## Fire Marshal Division

**Re: Buffalo Lake Medical**  
**85 Mattie Haddock Drive**  
**Cameron, NC 228326**

**Application Number 18-50043826**

**LIFE SAFETY PLAN**  
SCALE: 1/4" = 1'-0"

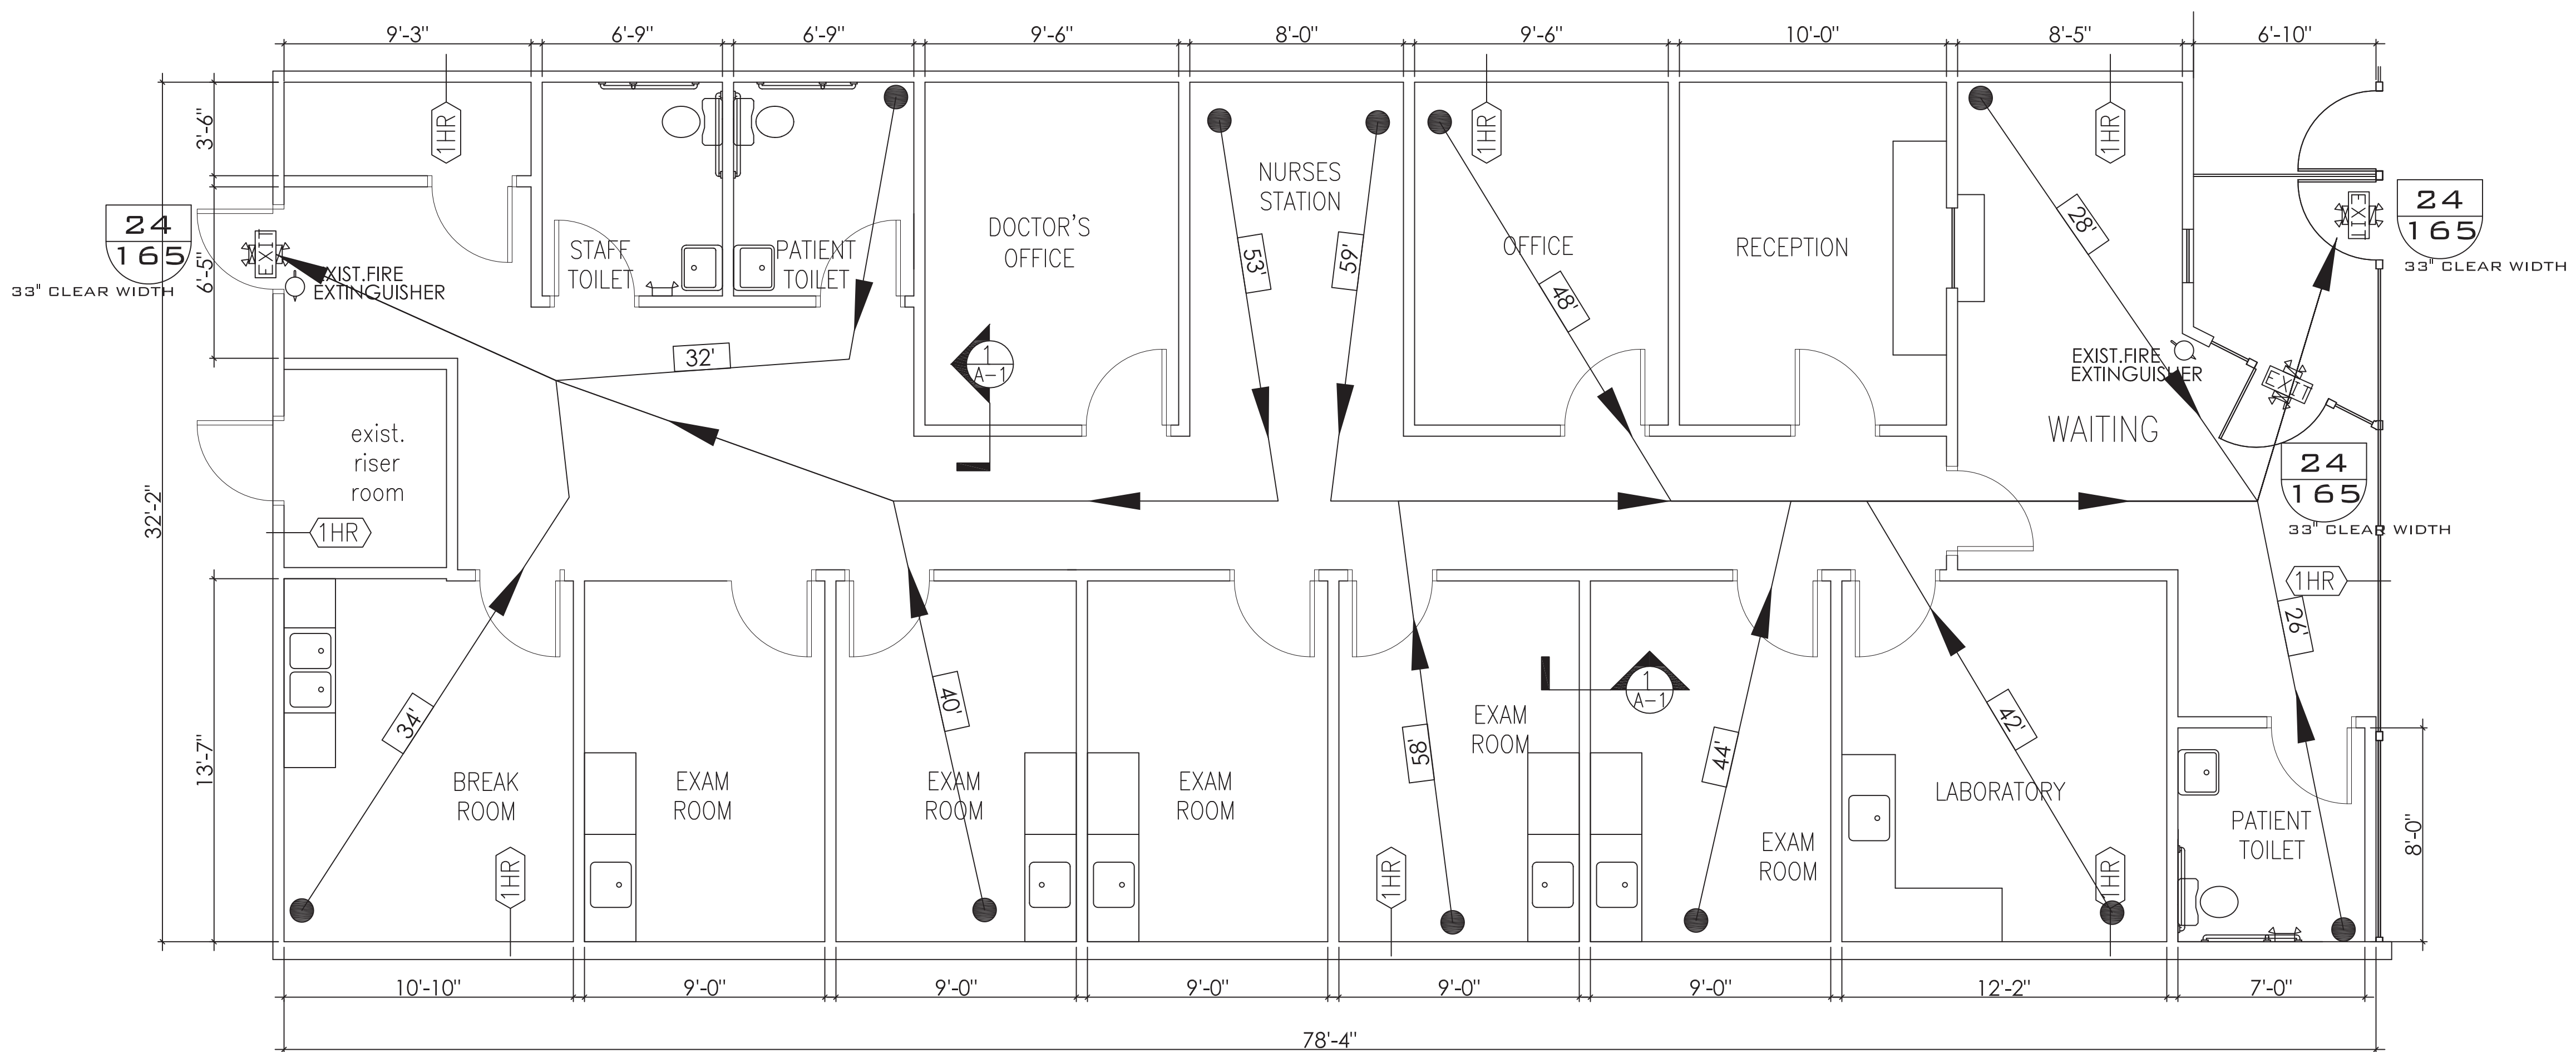
- **906.1 Fire Extinguishers**
  - Minimum of (1) 2A10:BC fire extinguisher shall be installed not to exceed 75' distance of travel.
  - All Fire extinguishers shall be properly mounted and tagged by a fire extinguisher company.

**PROPOSED REFLECTED CEILING PLAN**  
 SCALE: 1/4" = 1'-0"

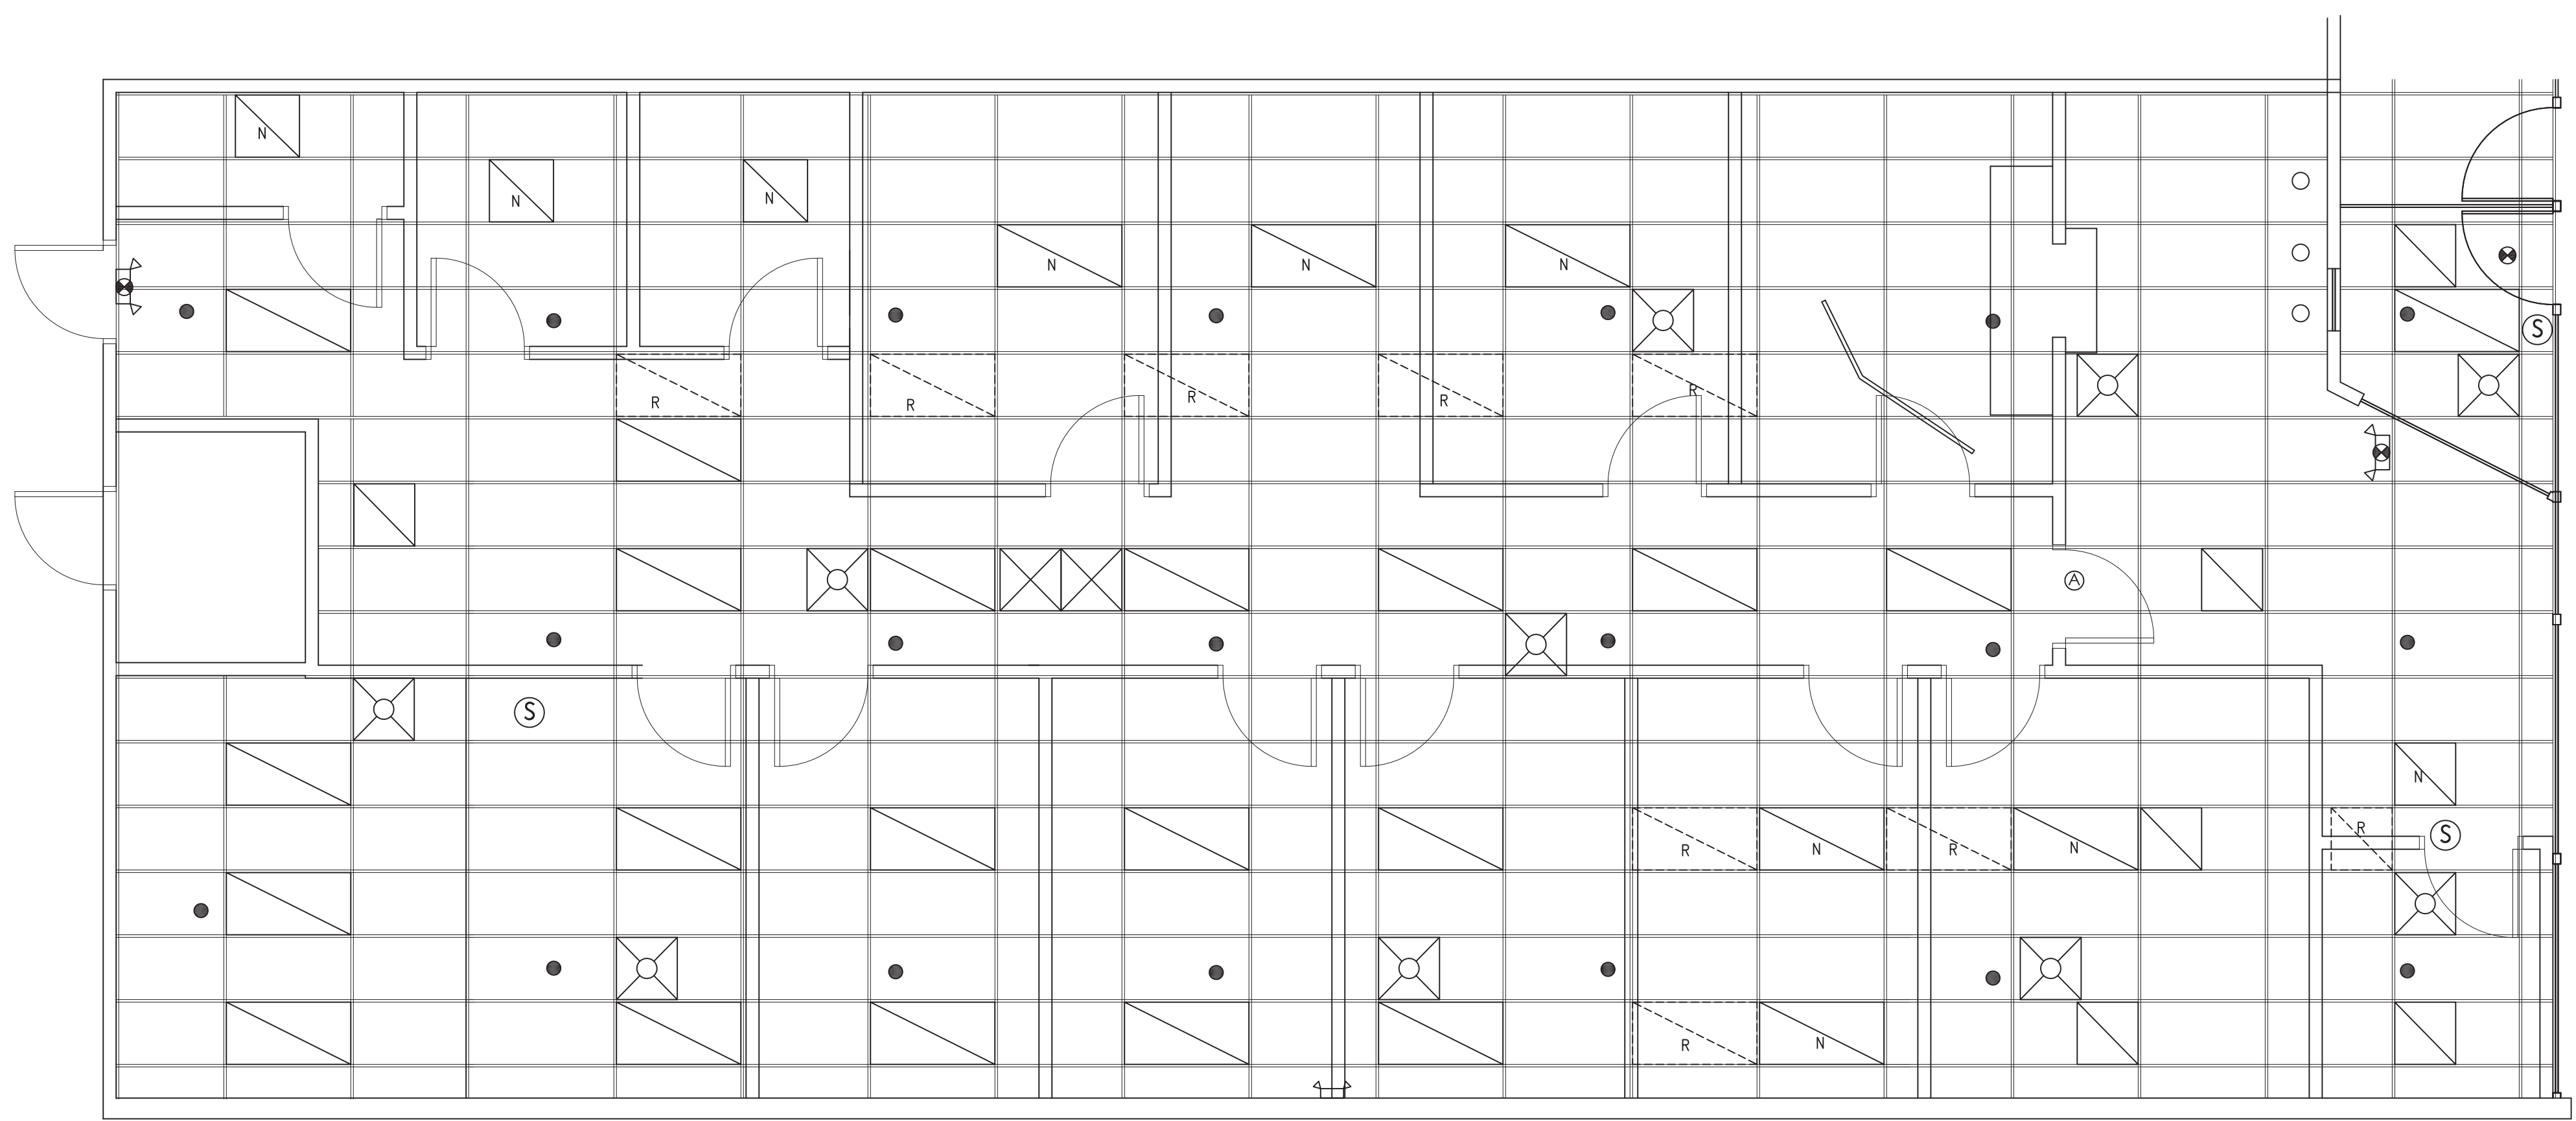
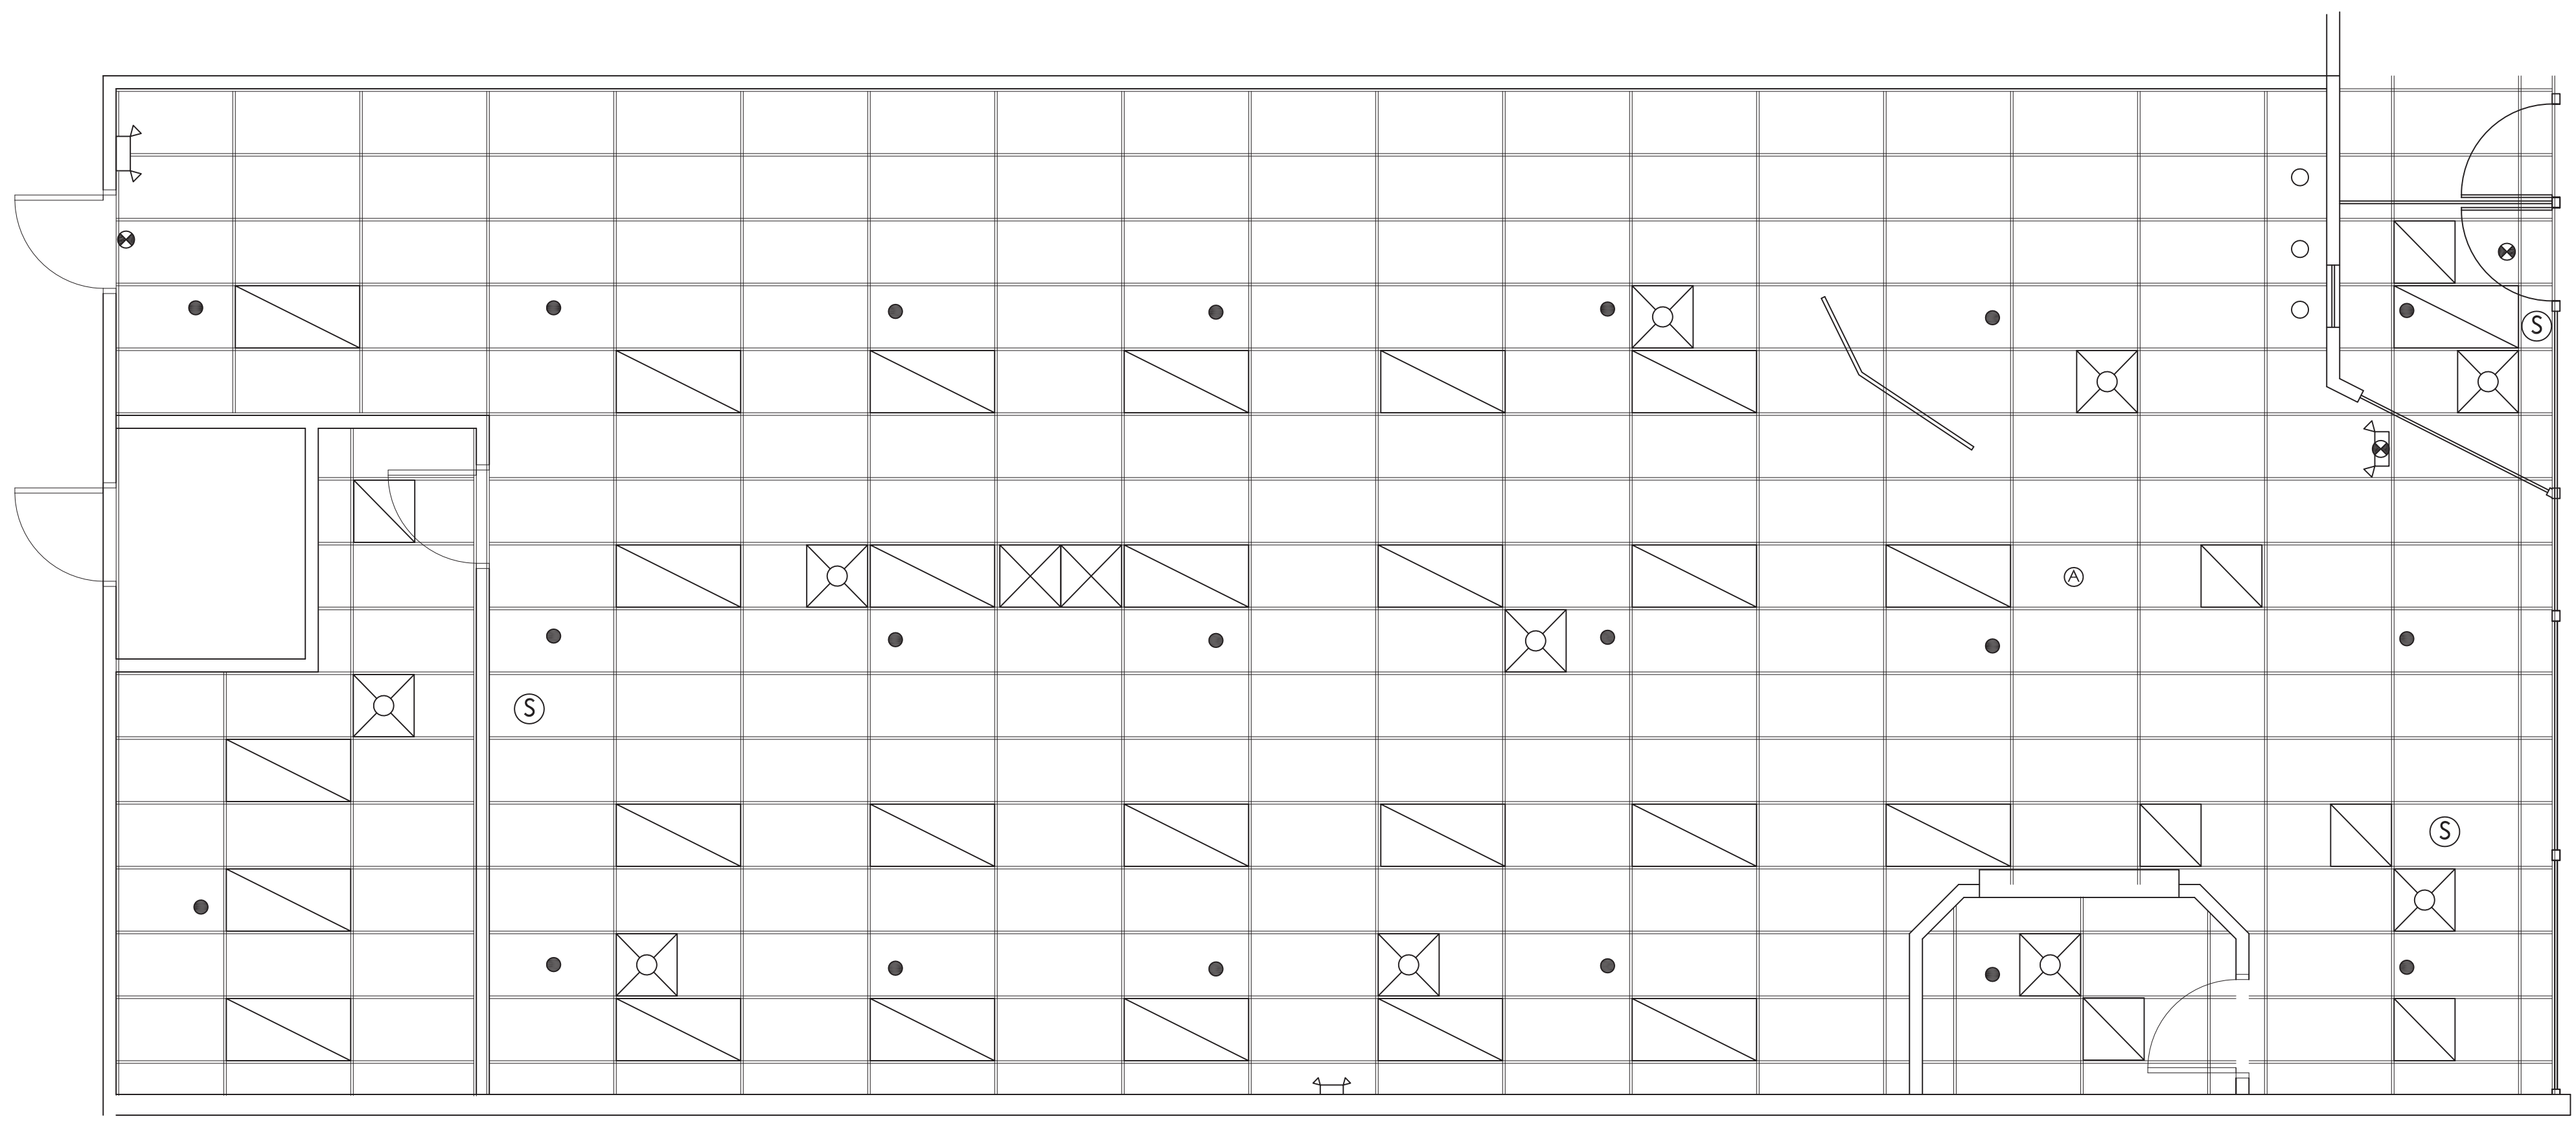
- **1006.1 Means of Egress Illumination**
  - The means of egress, including the exit discharge, shall be illuminated at all time the building space is served by the means of egress is occupied.
    - Means of egress consist of three separate and distinct parts: the exit access, the exit and the exit discharge.
  - The means of egress illumination shall not be less than 1 foot-candle at the walking surface.
